# Rezoning Transportation Analysis

Petition Number: 2020-136

General Location Identifier: Tax ID (04308515)

Date	Description
10-23-20	First Review (EL)

RZ-1.0

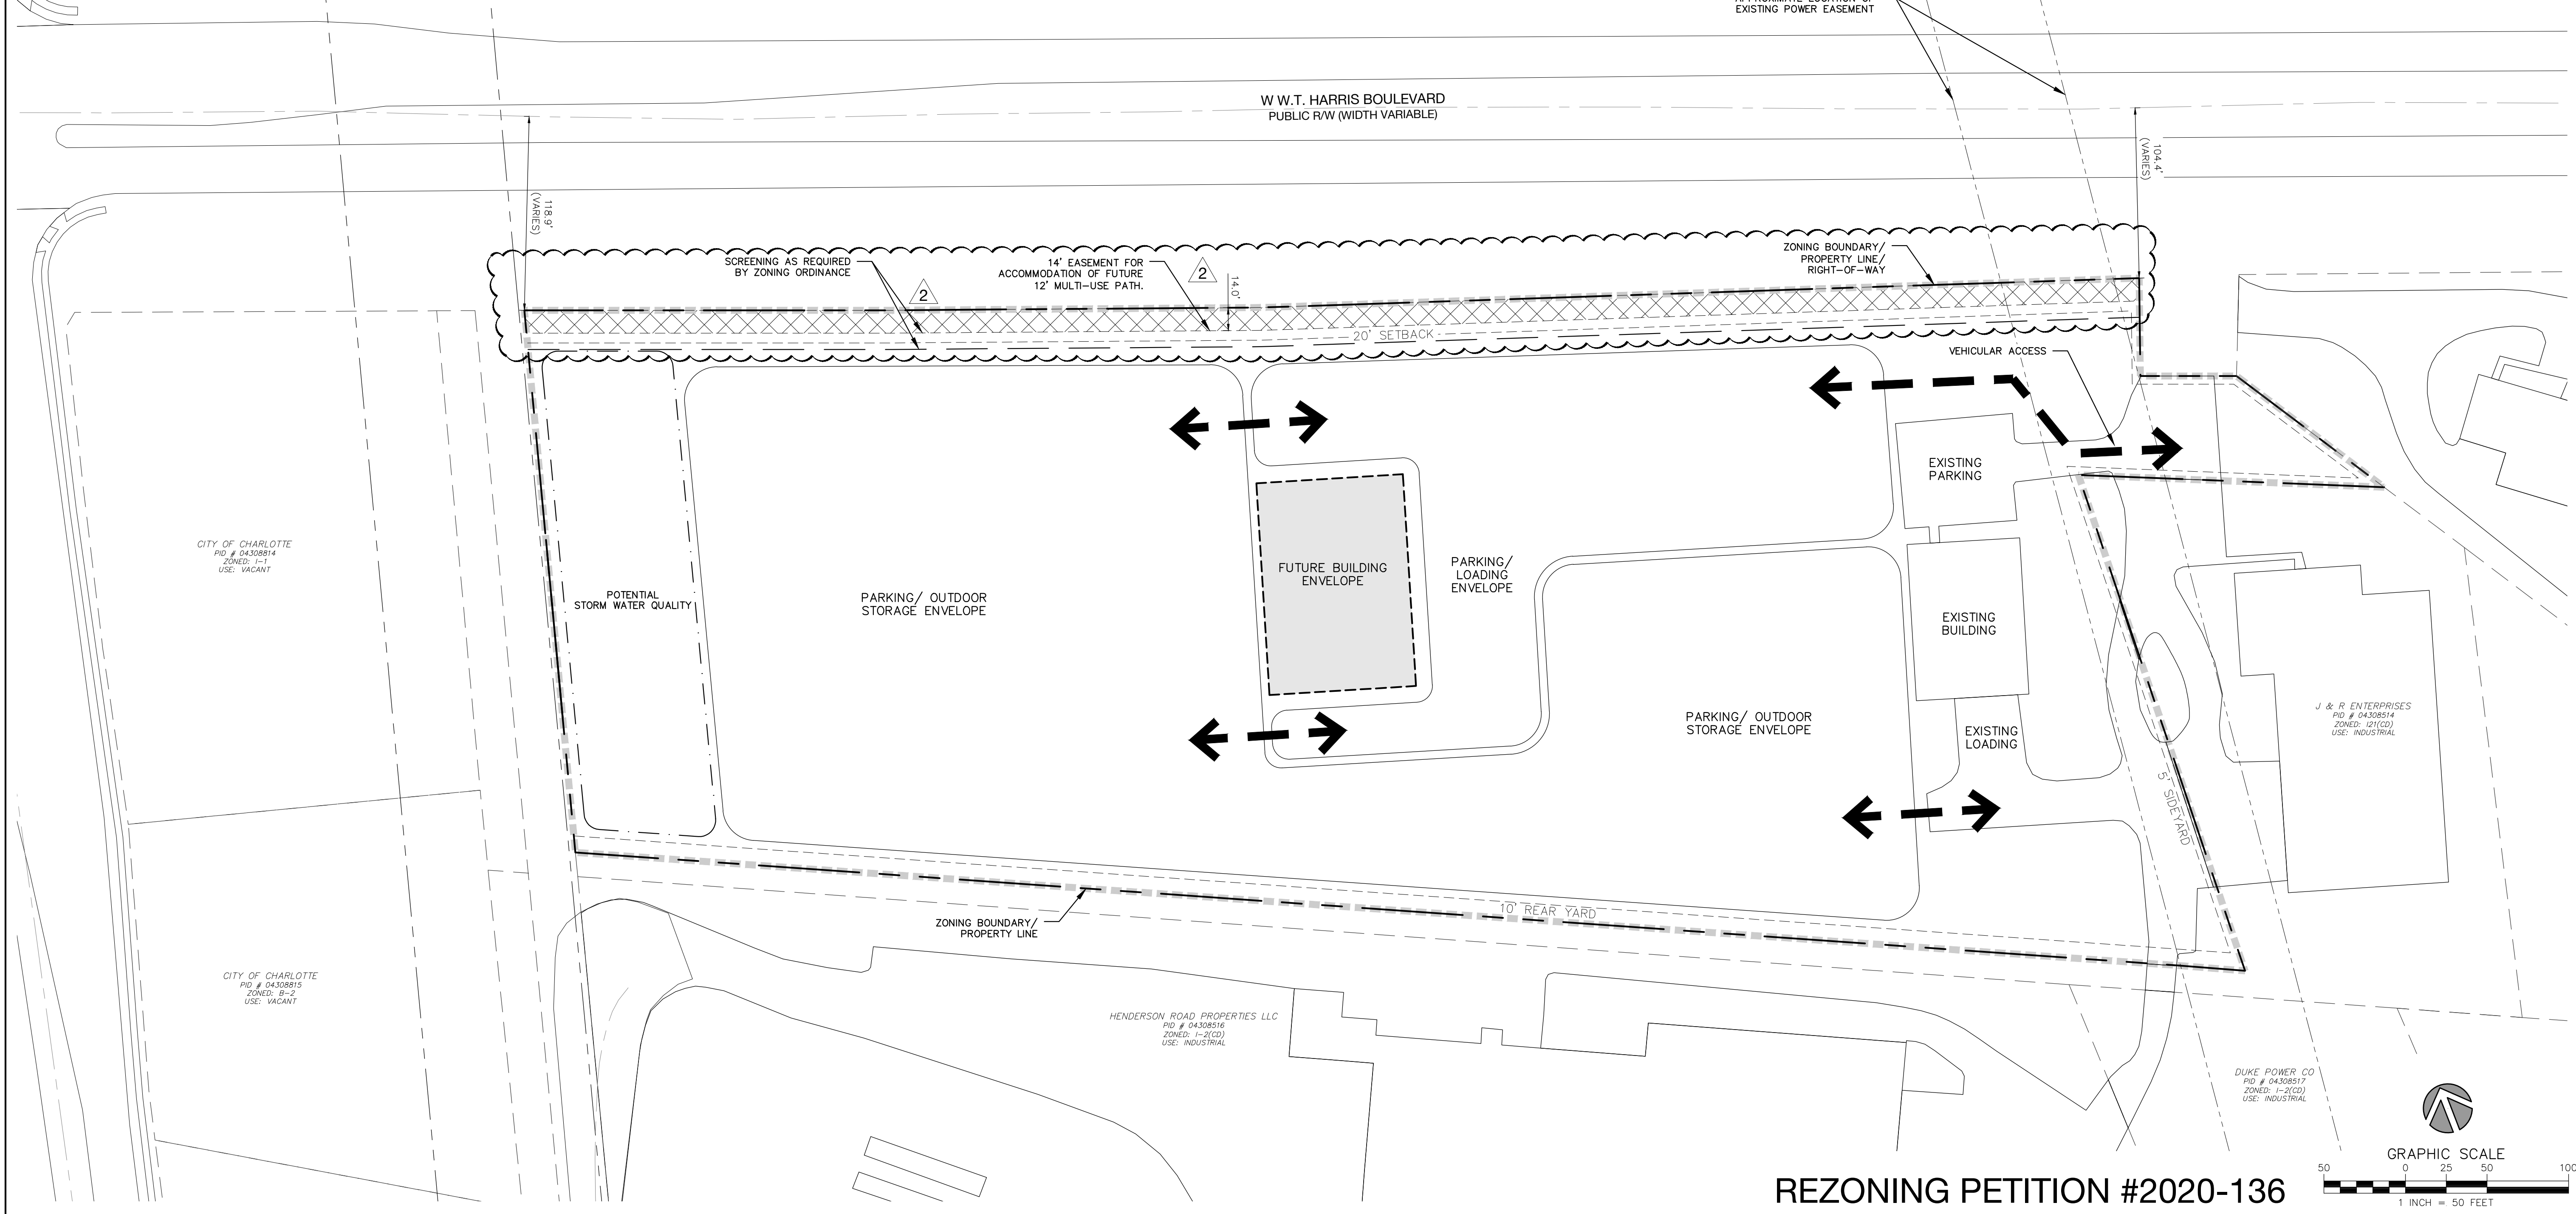
3. In reference to Section 12.103. of the Zoning Ordinance, revise the site plan and conditional note(s) to commit to dedicate a minimum of 100-feet of right-of-way from the WT Harris Boulevard road centerline. The site plan shall label and dimension the right-of-way from the road centerline.

4. Site plan and conditional note(s) revisions are needed to commit to construct bicycle facilities by installing a 12-foot multi-use path to meet the City of Charlotte BIKES Policy. The multi-use path needs to be installed outside of the WT Harris controlled access limits, per NCDOT, and contained within a sidewalk utility easement, installed 2-feet back of multi-use path.

5. Site plan and conditional note(s) revisions are needed to commit to construct the proposed vehicular access at the existing parking lot driveway, to meet NCDOT driveway stem length requirements, as noted within NCDOT's Driveway Access manual.

6. Site plan and conditional note(s) revisions are needed to commit to construct an eastbound right-turn lane on WT Harris Boulevard, as required by NCDOT, to mitigate traffic generated by the proposed rezoning site.

7. A site plan note specifying that all transportation improvements will be approved and constructed before the site's first building certificate of occupancy is issued is needed. The petitioner may phase transportation improvements if said improvements and phasing are explicitly described in site plan notes.
